## **M25 junction 28 improvement scheme**

**TR010029**

### **9.85 Applicant's comments on Hinson Parry & Company on behalf of Mr and Mrs Jones of Grove Farm's response to ExA WQ2**

April 2021

Client	MR L JONES & MRS K JONES		Scale	1:500	Status	FOR APPROVAL	
	Project	GROVE FARM ACCESS, JUNCTION 28 M25 NORTHBOUND SLIP LANE		Sheet Size		A3	Date
Status	Title		Drawing No.	REDW-3396-114		Rev	
	HGV ENTRY AT PROPOSED NEW ACCESS TO GROVE FARM

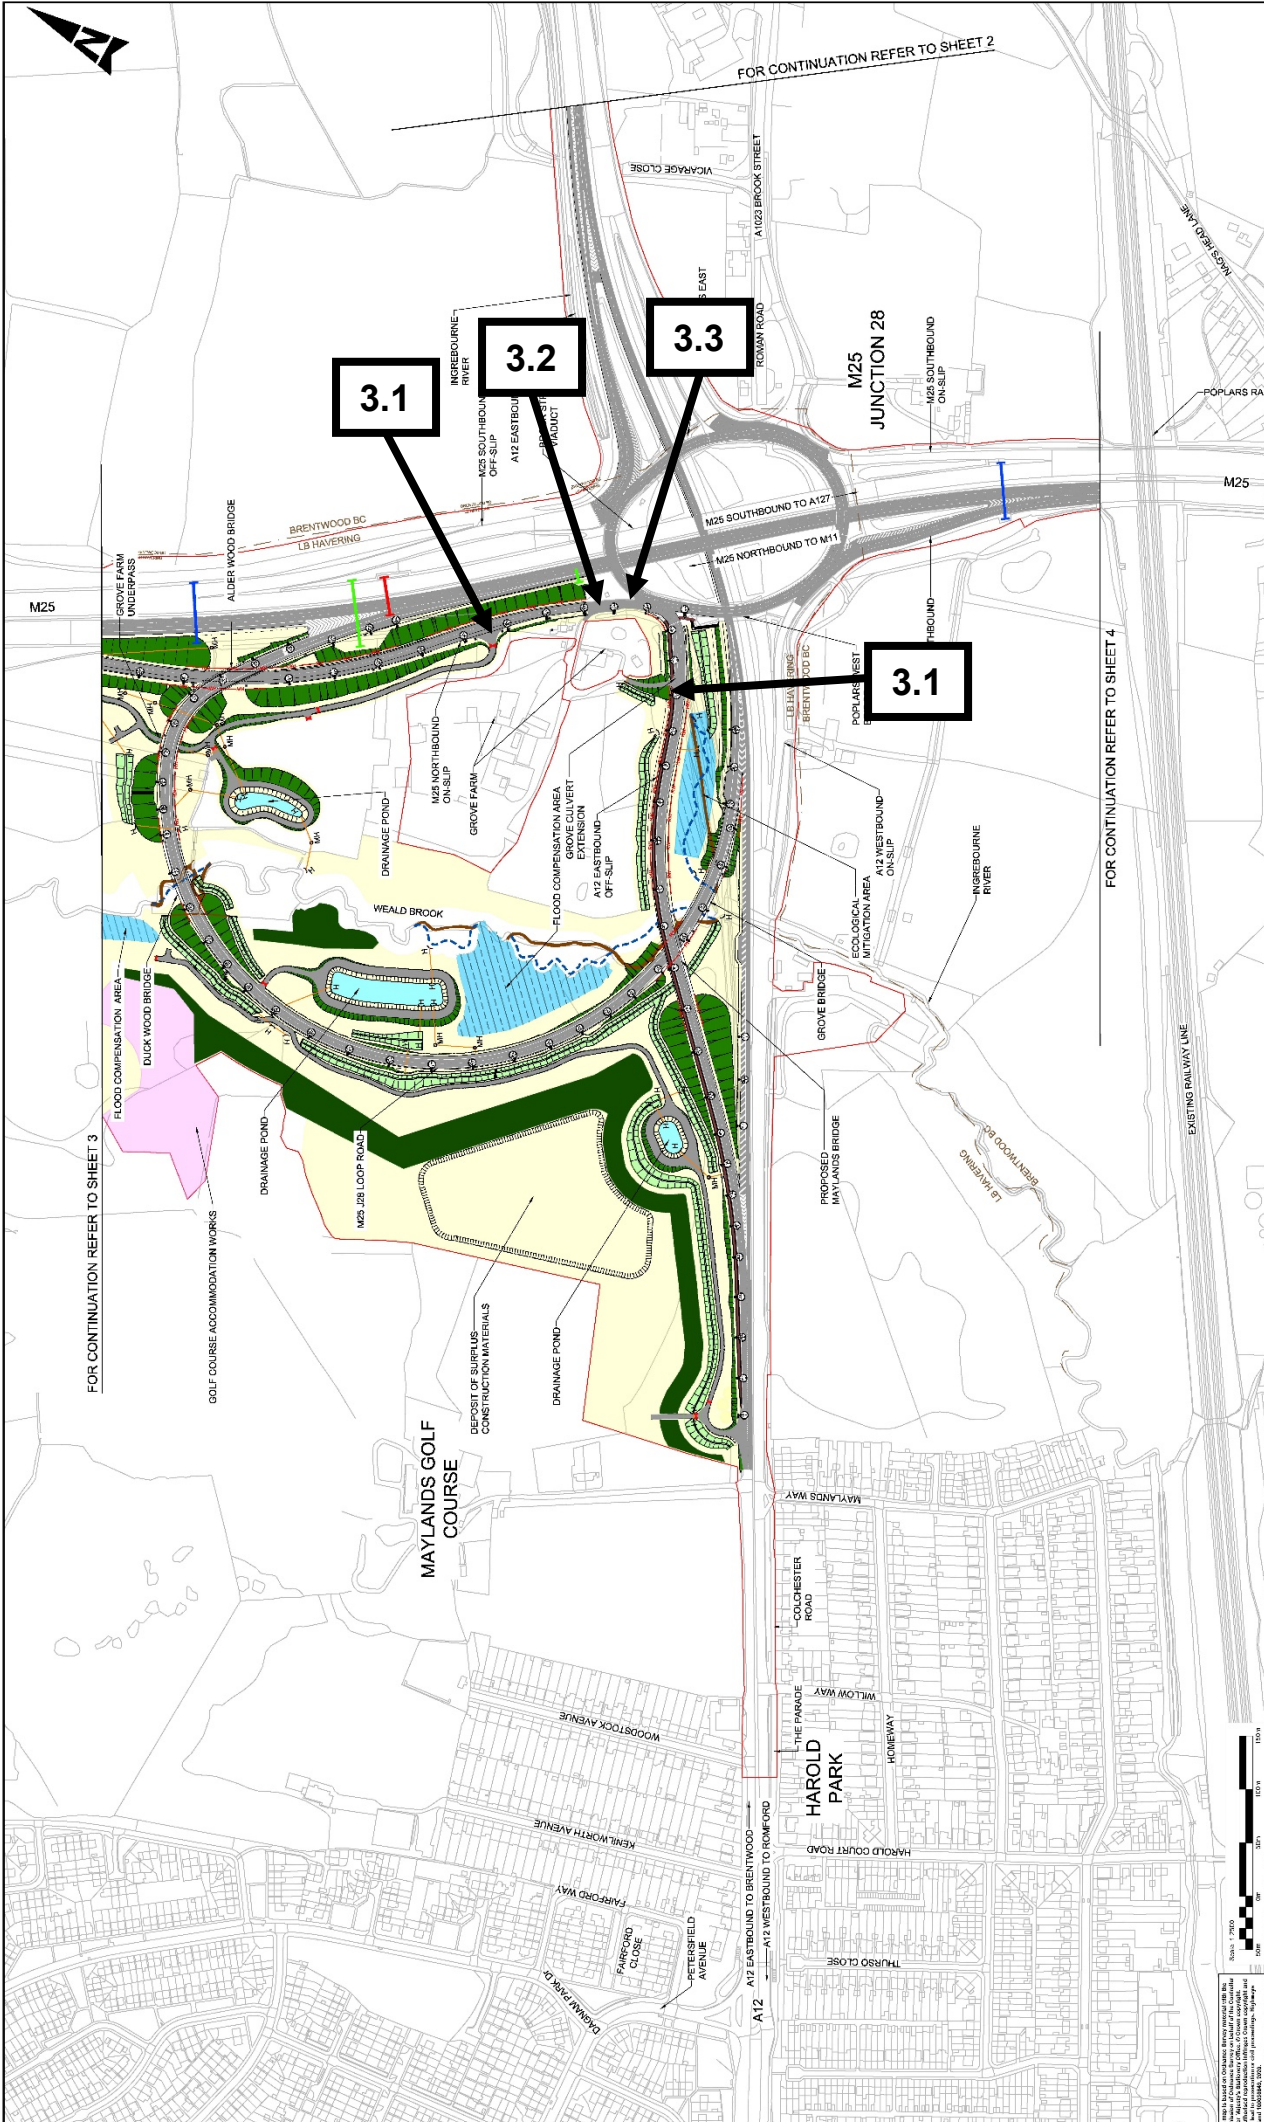
REP5-067-05	<p><b>2.5</b> It is confirmed by Grove Farm that Grove Farm requests that the Examining Authority require HE to include in an amended HE Scheme, farm access proposals as shown on <b>Drawing No. REDW-3396-115</b> including the following:</p> <ul style="list-style-type: none"> <li>i) The closure of the existing access to Grove Farm from the M25 northbound on-slip;</li> <li>ii) The construction of a new dedicated auxiliary left-turn lane access to Grove Farm from the M25 northbound on slip road to be shared with the HE service access already proposed for pond maintenance and electricity board vehicles.</li> </ul>	<p><i>Please see responses to REP5-067-01 to REP5-067-04 above.</i></p> <p>Highways England maintains its position that the Scheme has been developed such that it does not affect the arrangements for access to Grove Farm from the M25 northbound on-slip, and that no alteration to the M25 on-slip is proposed between the roundabout and the Grove Farm access, including the existing access itself.</p>

**Fig 3.1 - HE Indicative alignment of amended Grove Farm egress (Change 8)**

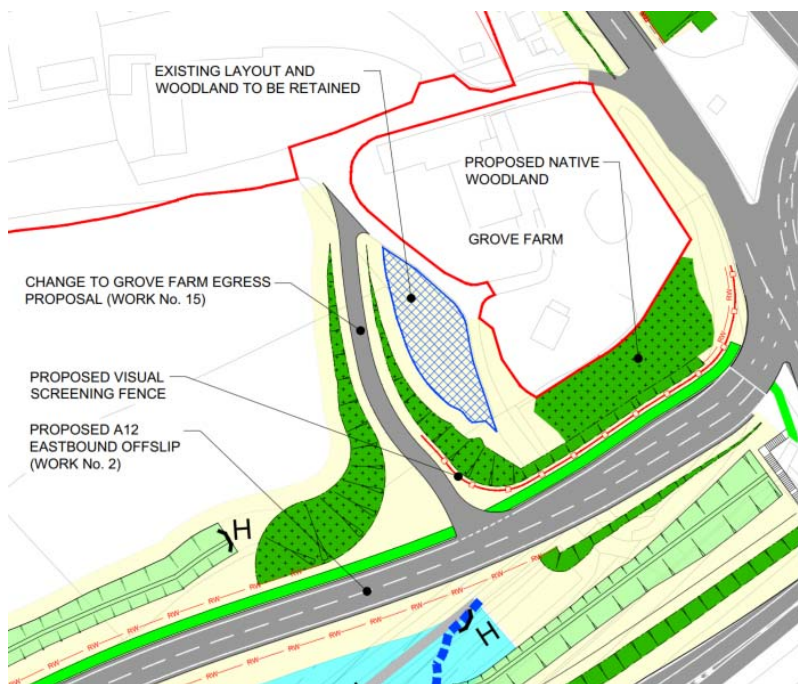
Response reference:	Representation Issue	HE Response
REP5-067-09	<p><b>3.3</b> Grove Farm welcomes this response from HE with regards alteration of the farm egress onto the A12 eastbound off-slip as the relocation of the farm egress will:</p> <ul style="list-style-type: none"> <li>i) Move queuing traffic leaving the site further away from the farmhouses;</li> <li>ii) Allow for the inclusion of a reasonably sized landscaped area between the farmhouse;</li> <li>iii) Allow for the inclusion of suggested noise attenuation barriers;</li> <li>iv) Provide traffic leaving the farm heading south on the M25 with more distance to adequately cross to the right-hand lane when approaching the roundabout.</li> </ul>	<p>Highways England welcomes this positive response regarding the alteration of the egress onto the A12 eastbound off-slip. However, Highways England would point out that noise attenuation barriers are not proposed to be provided for the reasons already given (REP5-067-11 below). With regard to point iv), although it has been possible to propose moving the egress a short distance further to the west in order to address the amenity concerns within Grove Farm and providing screening from the farmhouse, the egress point on the A12 slip road is only a short distance from that included in the dDCO. Highways England considers that it would not be appropriate for the egress to be located any further west for highway safety reasons.</p>

**Figure 3.2 – Grove Farm's suggested location for extra noise attenuation fencing**

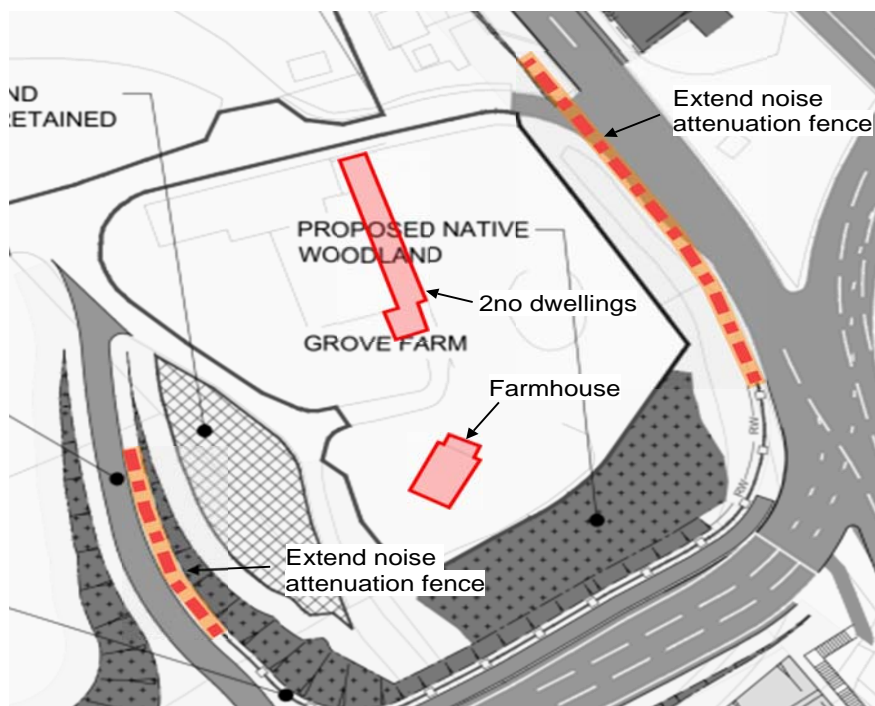
Response reference:	Representation Issue	HE Response																																				
	<p>mitigation measures are included in the HE Scheme surrounding Grove Farm. Our <b>Drawing No. REDW-3396- 115</b>, previously issued, showed Grove Farm's suggested location of permanent noise attenuation barriers which would contribute towards the enhancement of Grove Farm's environment and mitigate increased environmental traffic noise brought about by the HE Scheme. HE proposals for additional landscaping or standard visual fencing will not provide any material benefit for traffic noise reduction [ExA question - PC2.3 (ii)]. HE has dismissed any need for noise attenuation barriers based upon their noise assessment and has not worked with Grove Farm with a view to include a noise attenuation barrier in the HE Scheme; only suggesting visual fencing [ExA question - PC2.4 (ii)].</p> <p><b>4.2</b> <b>Figure 4.1</b> shows an extract of our <b>Drawing No. REDW-3396-115</b> showing Grove Farm's suggested line for permanent noise attenuation fence (highlighted in orange):</p> <p><b>Figure 4.1 – Grove Farm's suggested location for noise attenuation fencing</b></p>	<p>As the impacts at Grove Farm are negligible there is no justification for Highways England to provide any permanent noise mitigation at this location given the substantial cost to the public purse that this would involve.</p> <p>Further, the noise assessment shows that the current noise levels at Grove Farm are high, with higher noise levels only occurring at a limited number of other properties within the study area, principally on Colchester Road.</p> <p>At Grove Farm the existing noise levels are dominated by noise from the M25 motorway mainline carriageway, which is elevated above the junction 28 roundabout, and above Grove Farm. The least beneficial noise impact of the Scheme at Grove Farm is on the first floor of the south-east façade, which also has the highest baseline noise levels. The contribution of noise at this receptor, from the different elements of the surrounding road network and the proposed loop road, is indicated in the following table.</p>

<p>The table shows that noise from the M25 carriageway is approximately 6dB higher than the total noise from the junction (all slip roads, the roundabout and the proposed loop). This in turn illustrates that reductions in noise from any road other than the M25 carriageway would have very limited benefits on the total noise levels at Grove Farm.</p>	Noise levels in dB LA10,18h 1m from facade	Existing (2022)	Scheme (2022)	Change with Scheme	M25 carriageway	72.1	72.0	-0.1	M25 slip roads	60.8	60.7	-0.1	A12 Carriageway	60.0	58.4	-1.6	A12 slip roads	62.5	62.9	0.4	J28 roundabout	62.8	61.7	-1.1	Proposed loop road	-	46.9	-	Total noise	73.4	73.3	-0.1	Total junction	66.9	66.7	-0.2
Noise levels in dB LA10,18h 1m from facade	Existing (2022)	Scheme (2022)	Change with Scheme																																			
M25 carriageway	72.1	72.0	-0.1																																			
M25 slip roads	60.8	60.7	-0.1																																			
A12 Carriageway	60.0	58.4	-1.6																																			
A12 slip roads	62.5	62.9	0.4																																			
J28 roundabout	62.8	61.7	-1.1																																			
Proposed loop road	-	46.9	-																																			
Total noise	73.4	73.3	-0.1																																			
Total junction	66.9	66.7	-0.2																																			
REP5-067-12	<p><b>4.3</b> The HE Scheme will not reduce traffic flows and associated future traffic growth on the new and closer A12 eastbound off-slip or the M25 northbound on-slip both next to Grove Farm. The highlighted noise attenuation barrier shows the fence returning into the site at the existing farm entrance and our</p>	<p>The aim of the Scheme is to improve traffic flow through junction 28 and reduce queueing on the approaches, reducing the need for people to brake and accelerate near Grove Farm, thereby reducing some of the more distinctive elements of road traffic noise. The Scheme includes low</p>

Response reference:	Representation Issue	HE Response
	<p>suggested farm egress. These barrier returns will mitigate against increased noise from traffic flows on the closer A12 eastbound off-slip and the M25 northbound on-slip.</p>	<p>noise surfacing, and is expected to have a negligible impact on Grove Farm compared to a situation without the Scheme.</p> <p>Highways England considers that the performance of the two suggested barrier returns, as indicated on the plan submitted by Grove Farm at Deadline 5 (Figure 4.1 from REP5-067) would not provide effective noise mitigation as the improvement would be less than half a decibel. Particularly, the farm egress is at a lower level than the A12 slip road, and the corresponding lower height of the top of the barrier would have limited potential to reduce noise from the A12 slip road.</p>
REP5-067-13	<p><b>4.4</b> HE's current position on the effect of the HE Scheme on traffic noise is that their noise assessment has established such a significant base level of background noise from the M25 and A12 that the HE Scheme will not produce a material change in traffic noise sufficient to warrant inclusion of physical noise attenuation measures. Mr R Bedson representing Grove Farm at the Hearing referred to his experience in other projects where subsequent post-development noise measurements were greater than the pre-development assessment.</p>	<p>As noted in response REP5-067-11 above, the existing noise levels at Grove Farm are high and are dominated by noise from traffic on the M25 motorway mainline carriageway.</p> <p>Highways England does not agree that post-development noise levels are necessarily greater than the pre-development assessment. Post-opening noise measurements can be shown to vary from forecast levels. For example, for road traffic noise, Highways England would expect noise levels from measurements to be higher than predictions if the road surface is wet, because the calculations assume a dry surface. Equally, the calculations would be expected to be higher than the measurements when the wind blows from the measurement location to the road because the assessment assumes the wind blows from the road to the receptor location. The assessment uses an annual average traffic flow and there would be hour-to-hour, day-to-day and month-to-month variations in traffic giving rise to variations in noise which would not be shown in the predictions. The objective of the assessment is to allow decisions to be made, and the expected changes in noise levels and corresponding impacts of schemes can be compared on a like-for-like basis. It is not to predict the worst case noise levels out of any situation which may occur at a receptor, even though those living near roads are likely to note those more adverse times more than they would note the times when noise levels are lower.</p> <p>Mr Bedson has not provided any substantiation of his experience of noise levels as assessed being inaccurate in practice on other schemes, or the circumstances that arose on those schemes.</p>
